### Comments on Written Representations – Deadline 3 Submissions

### Deadline 3 Submission - 6.2 Environmental Statement Appendix 13C: Framework Construction Traffic Management Plan and Travel Plan (Tracked) - Rev 02

Drawing Number 60589004_ES_CTMP_002	Rev 01
---	------------------

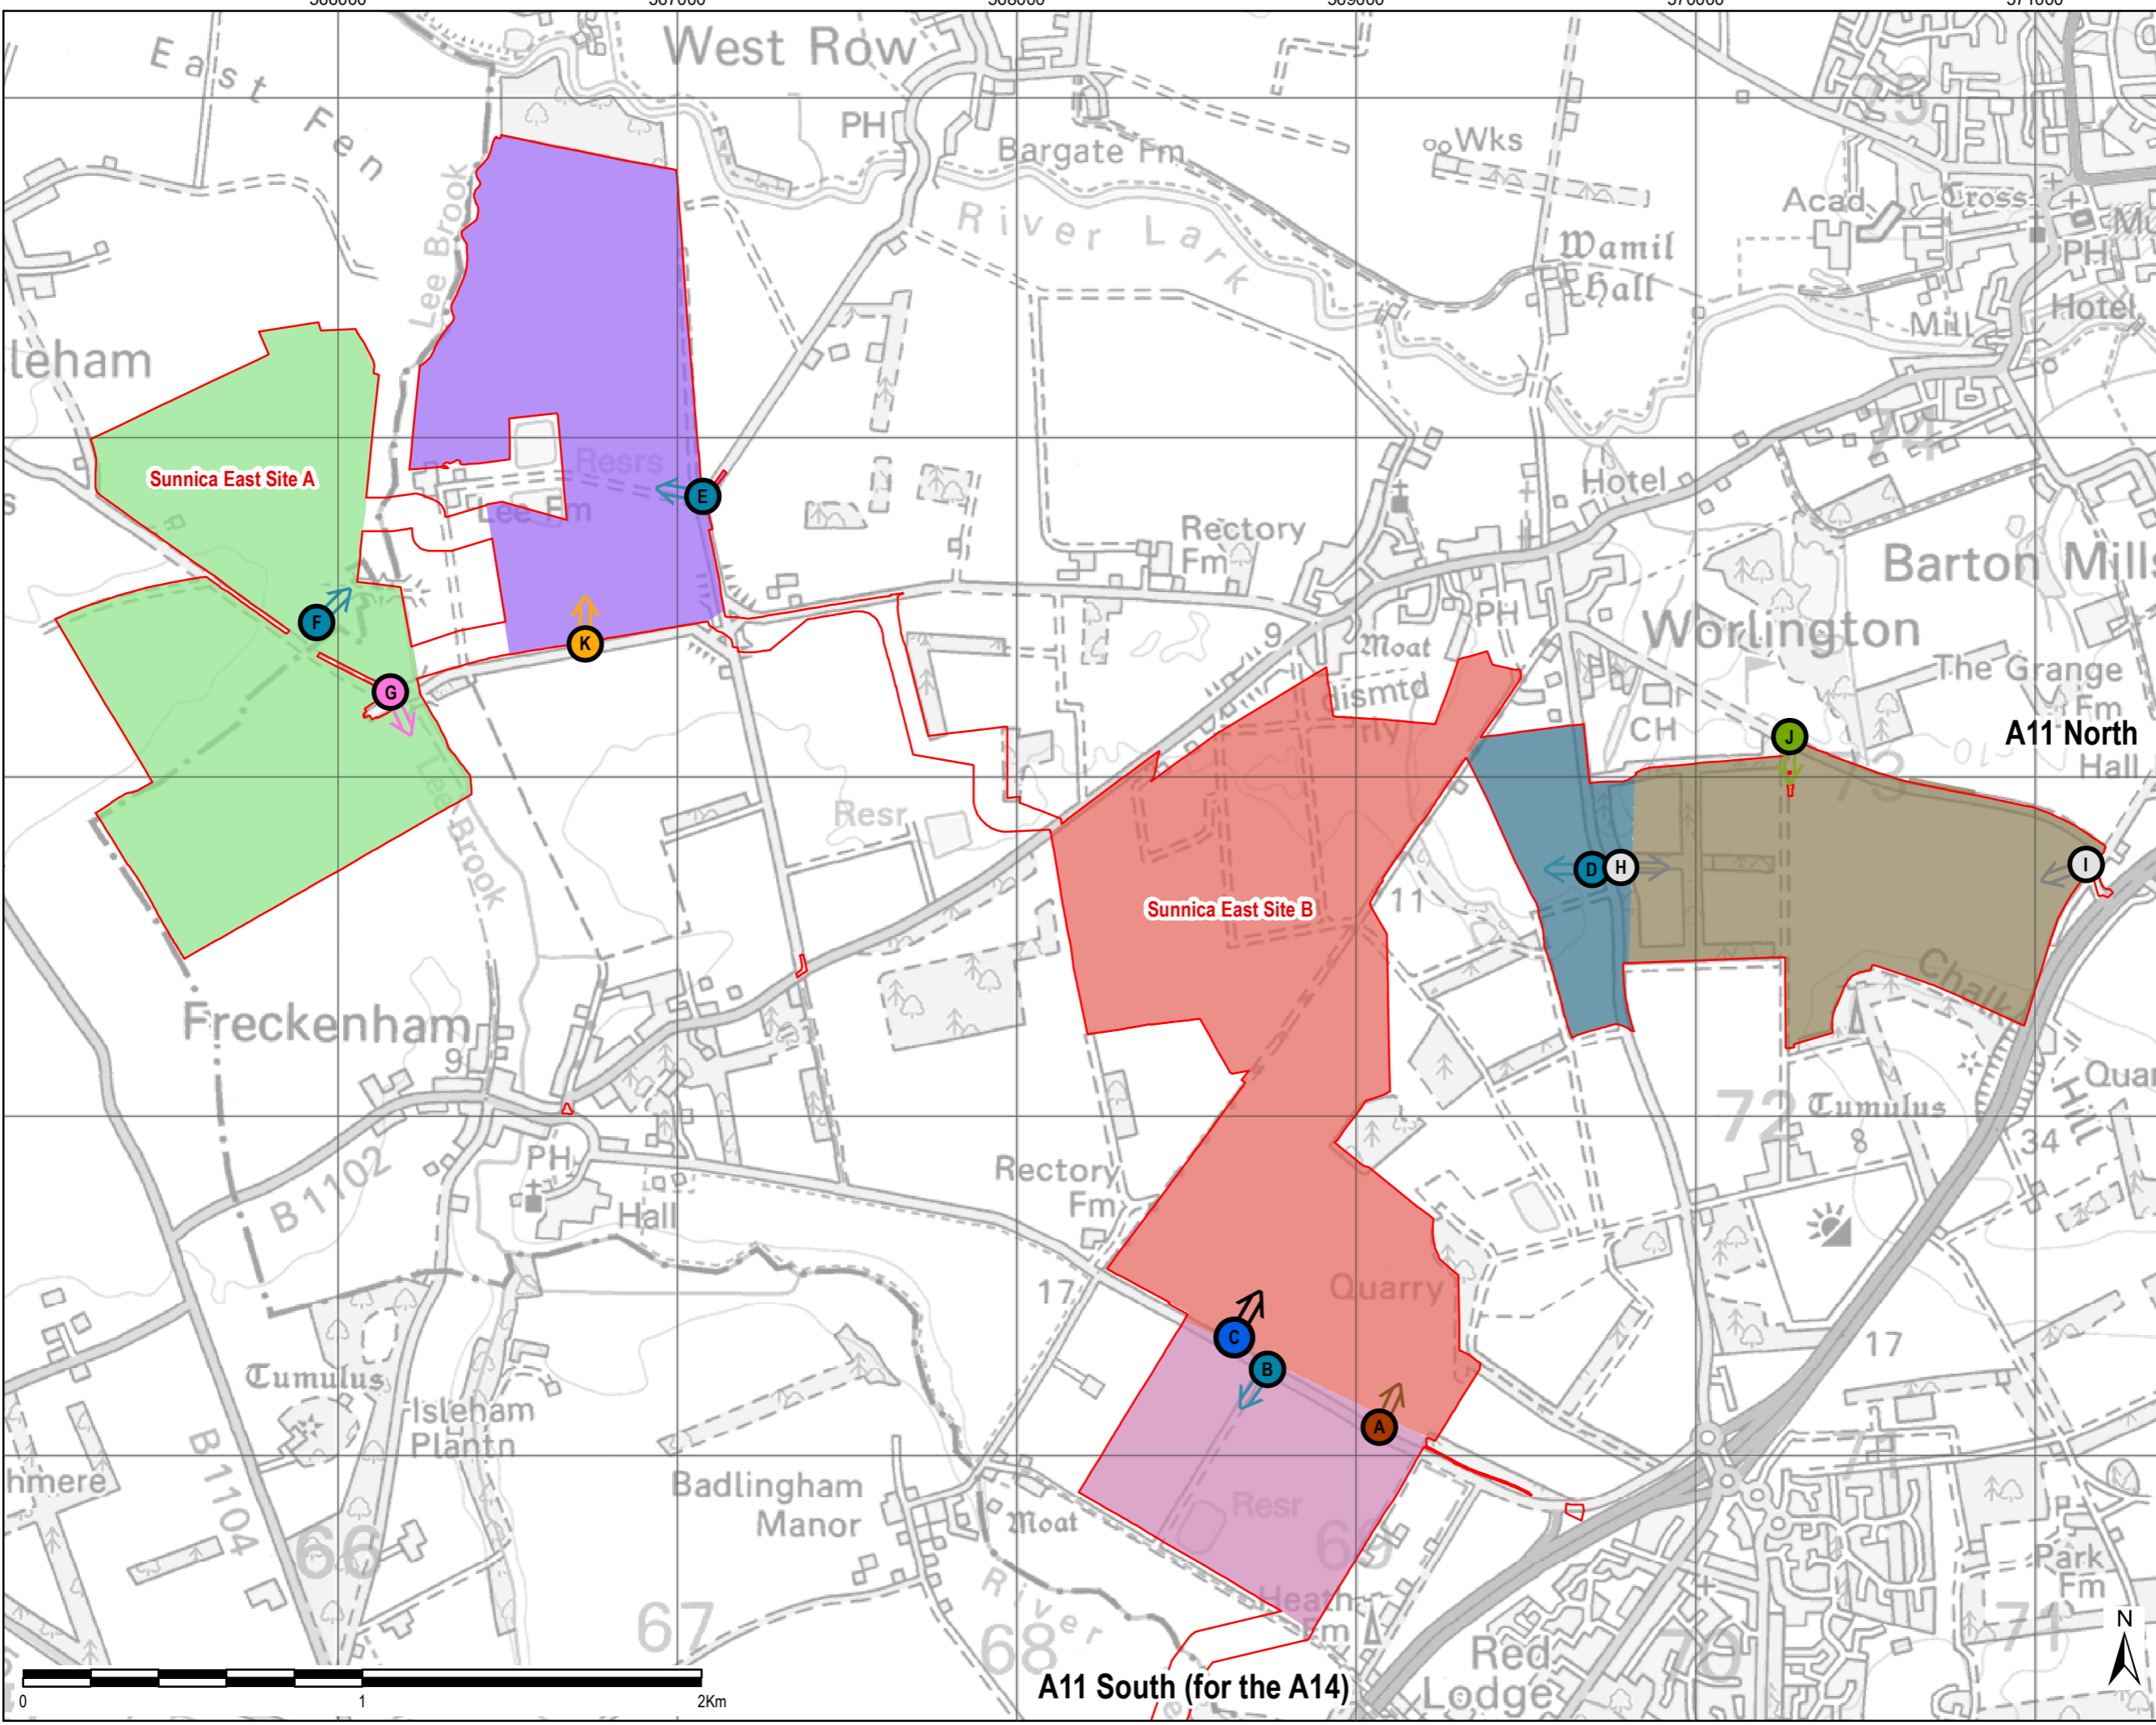
Sunnica states West Site access points B on Chippenham Road and D on Fordham Road are ‘existing access routes’ – they are actually rarely used field (primarily pedestrian) entrances. A further access point is omitted (see red square on image below). This access will also be used within construction, operational and decommissioning phases. Although shown as a relatively straight line on the map, it is actually a blind bend when approaching from Chippenham. This is not an existing access; it is a field verge without hedging.
